Re: Falcon Marketplace Final Plat (SF-19-001 CDR-16-007)

Please accept this response letter to your comments dated June 11, 2019

We trust you find our responses to the 3rd review of the Falcon Marketplace Final Plat acceptable. We look forward to working with the County in processing the submittal. Please call if you have any questions or require any additional information.

SURVEY CONTROL

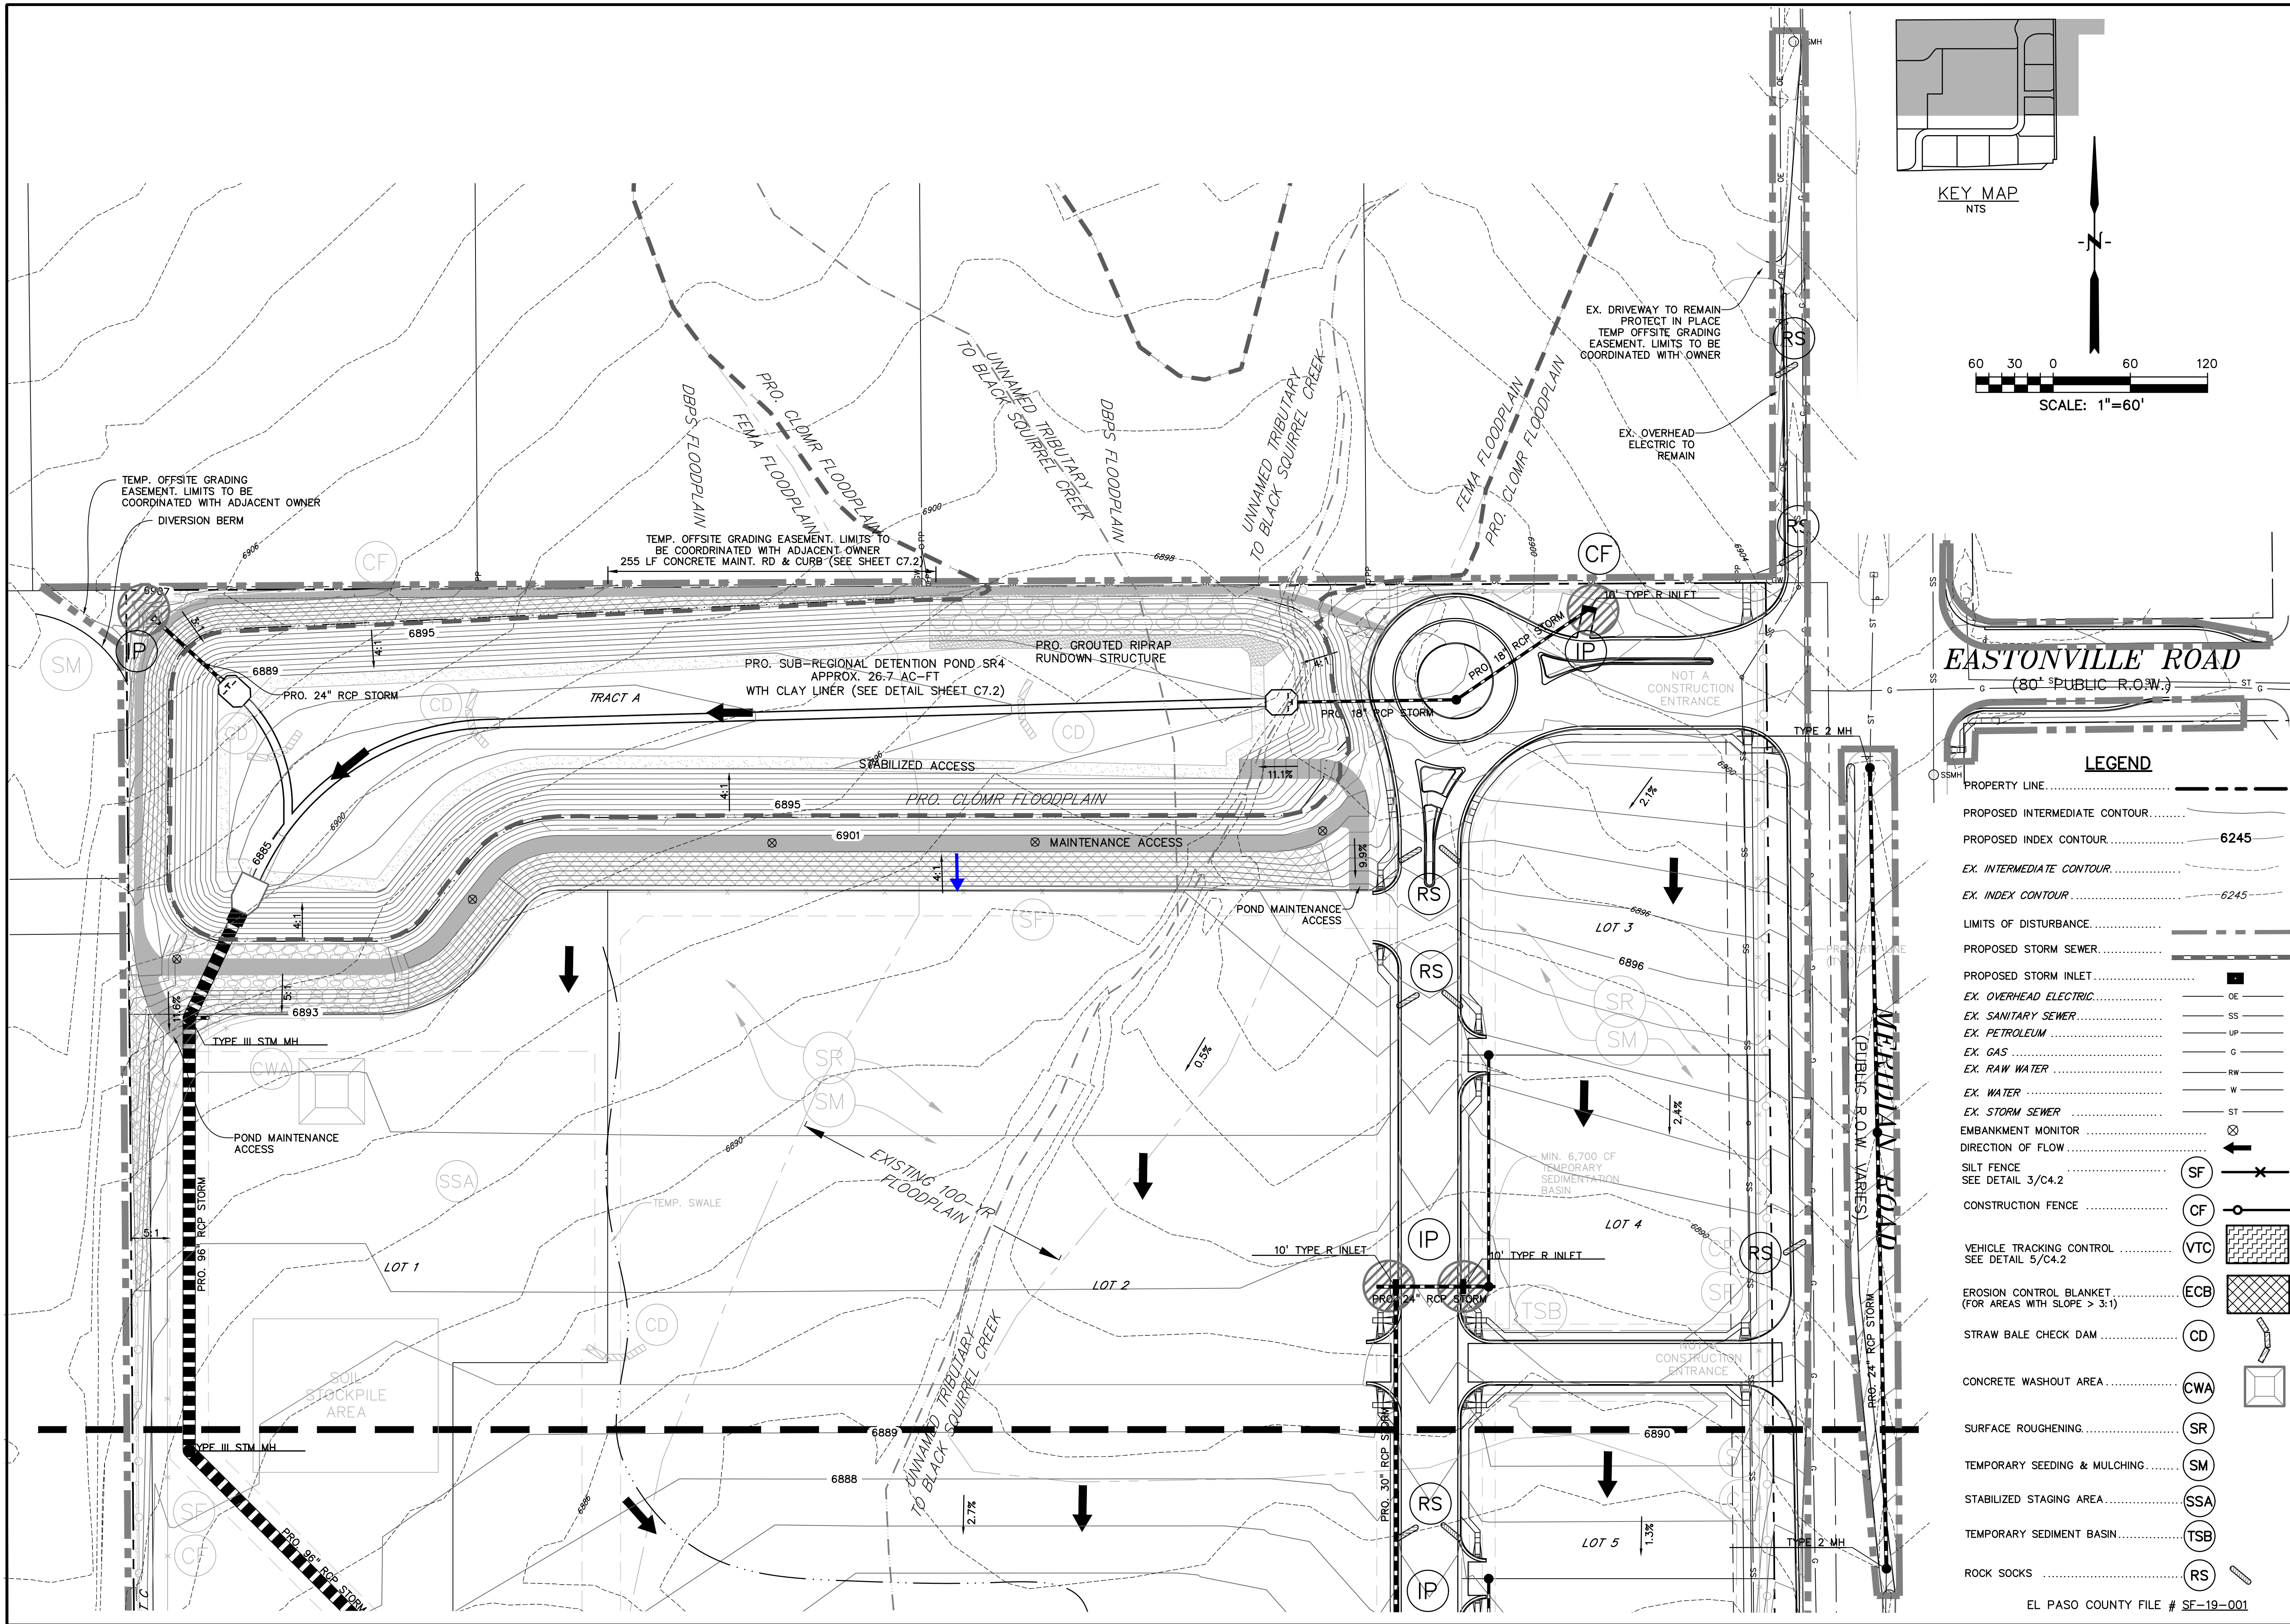
3. Provide a survey control plan, including basis of bearings with monumentation, tying control points and coordinates with all proposed road and storm drain alignments. Include the Pond SR4 monitoring information with locations and vertical control points. **Partially resolved; show the monitoring points and property lines along Eastonville Road east of Meridian. *Monitoring points and offsite property lines added.***

**C2.10**

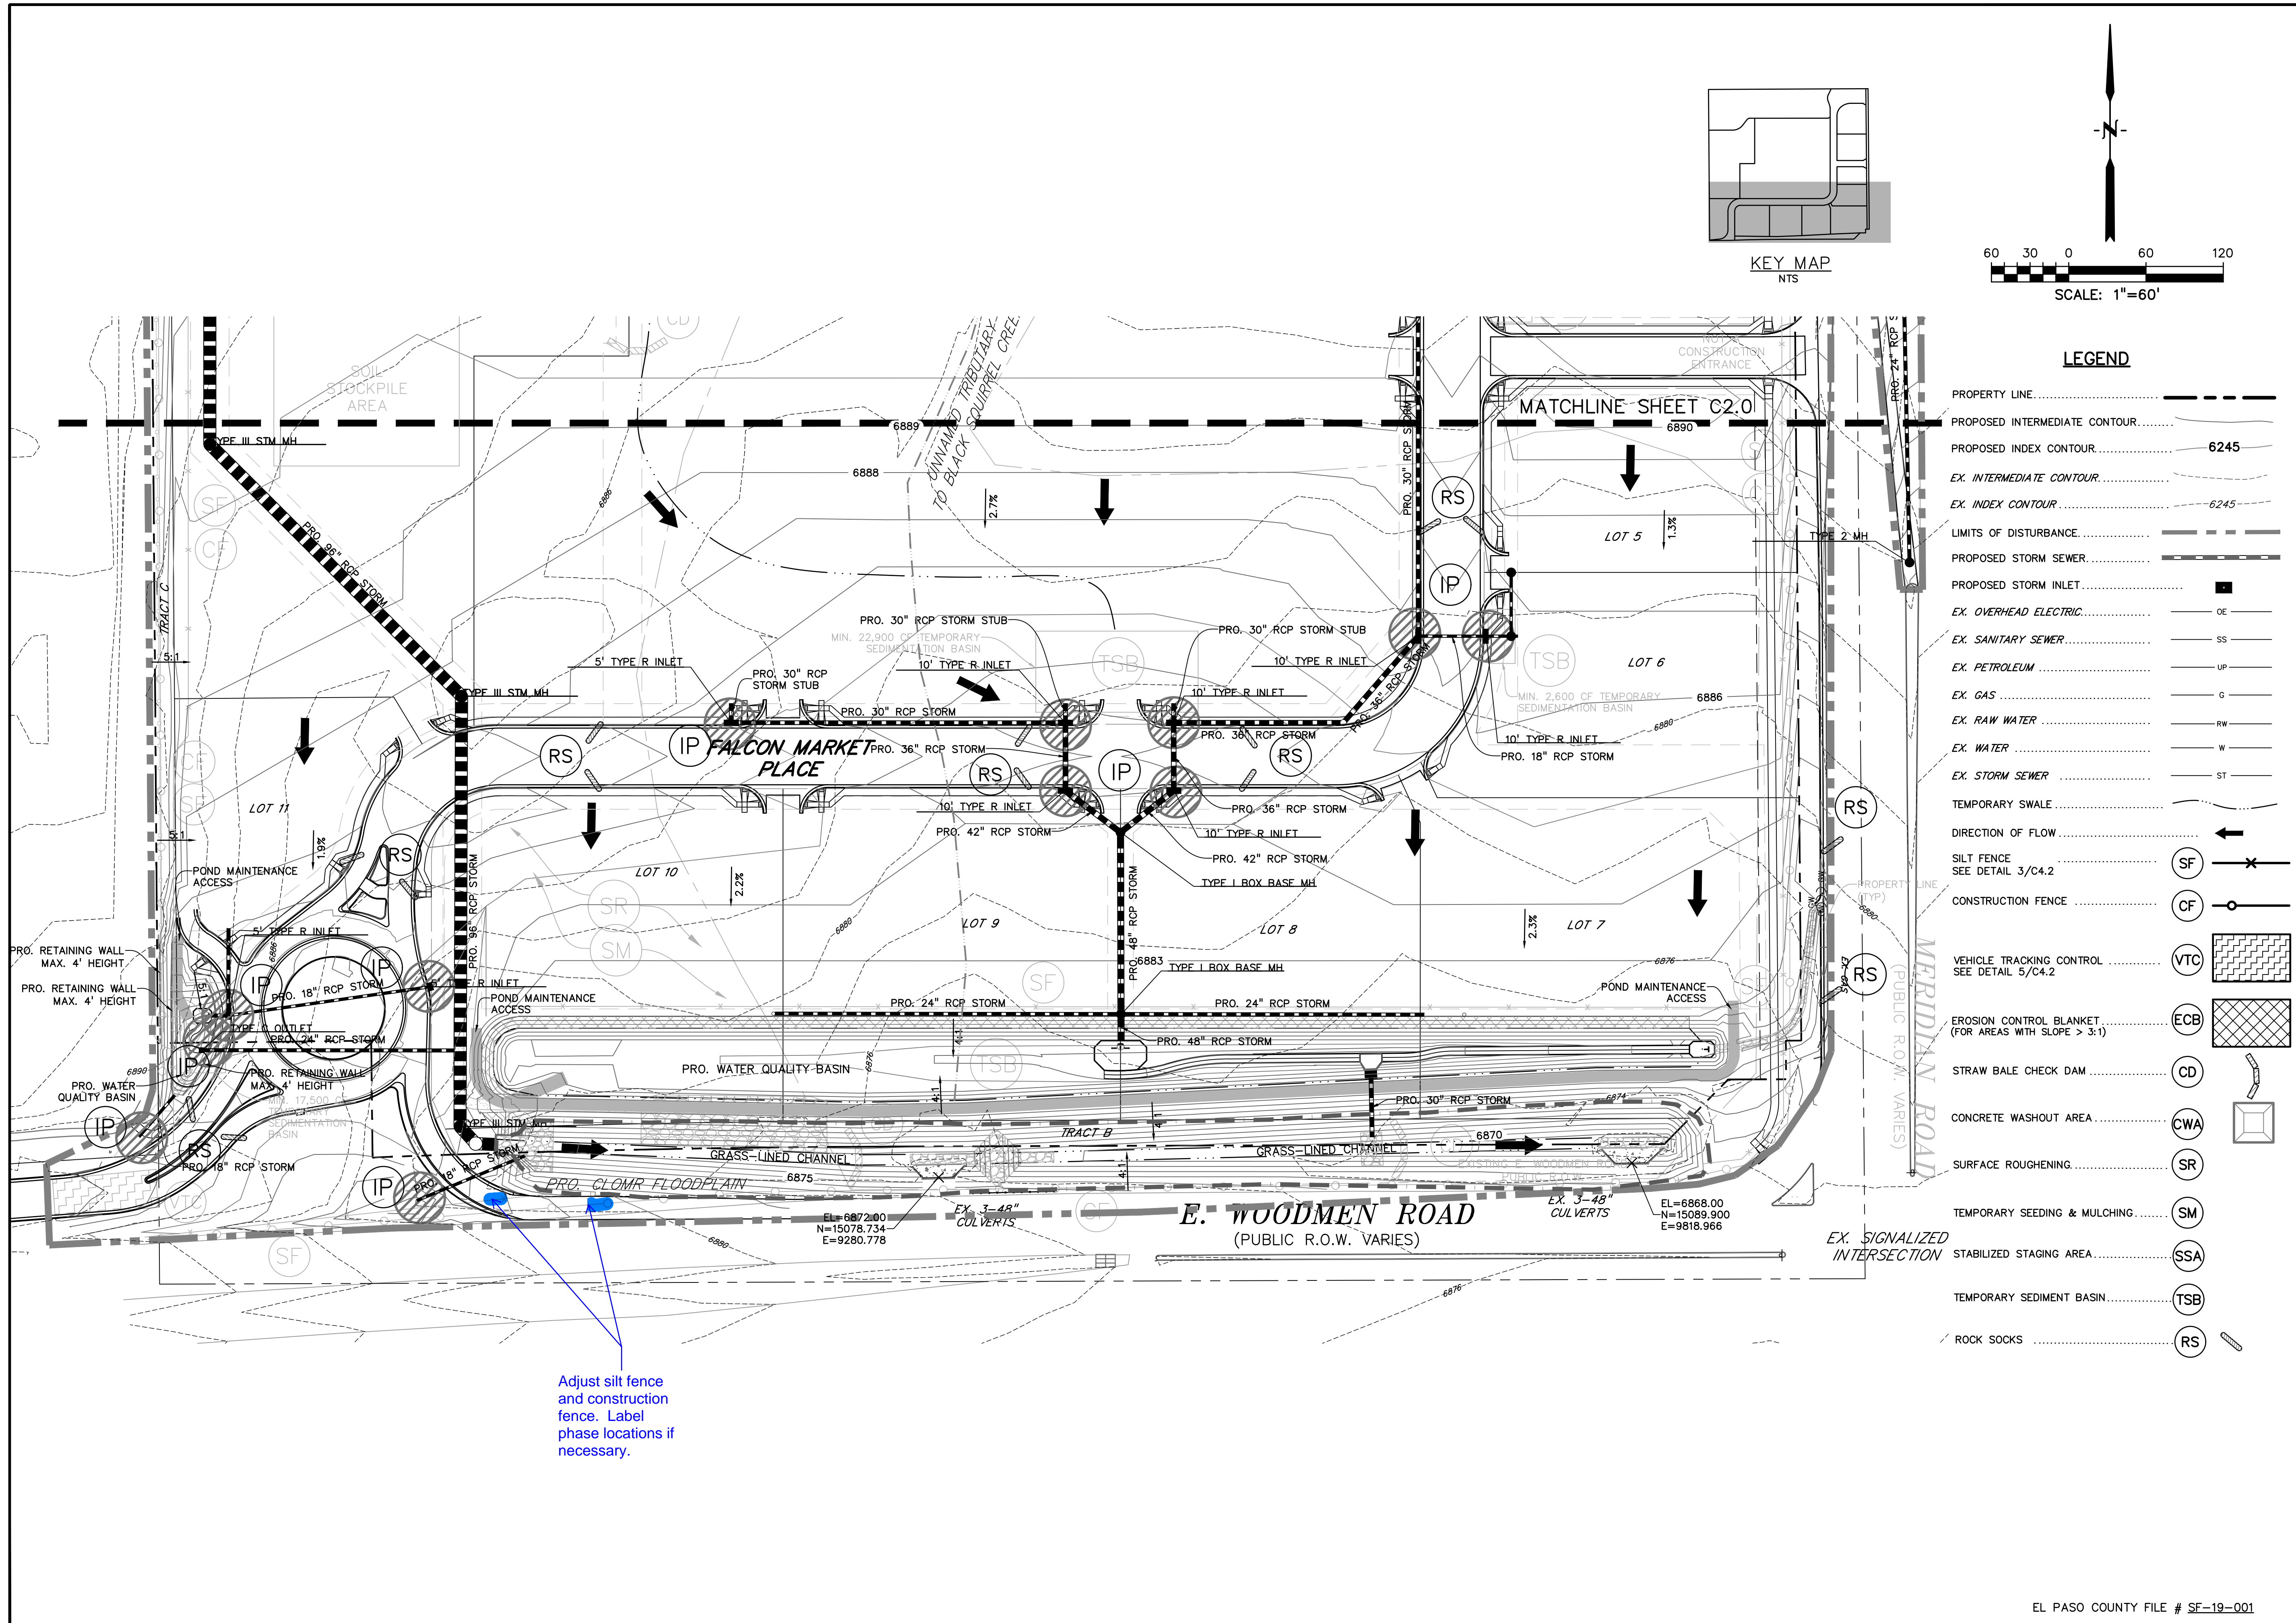
Subject: Cloud+
Page Index: 7
Date: 6/9/2019 10:09:59 AM
Author: dsdrice
Color: ■
Layer:
Space:
Page Label: [7] 7 C2.10

include this area

Subject: Callout
Page Index: 7
Date: 6/9/2019 10:25:45 AM
Author: dsdrice
Color: ■
Layer:
Space:
Page Label: [7] 7 C2.10

Use same symbol as detail sheet, add to legend;
adjust location of this one

Subject: Callout
Page Index: 7
Date: 6/9/2019 9:52:00 AM
Author: dsdrice
Color: ■
Layer:
Space:
Page Label: [7] 7 C2.10

Existing driveway to be (removed, protected?)

Subject: Callout
Page Index: 7
Date: 6/9/2019 9:54:14 AM
Author: dsdrice
Color: ■
Layer:
Space:
Page Label: [7] 7 C2.10

arrow direction?

Limits of disturbance extended around
new sidewalk

All curb socks relabeled to RS. This one
adjusted outside of driveway

Note to protect in place added plan

Arrow direction adjusted
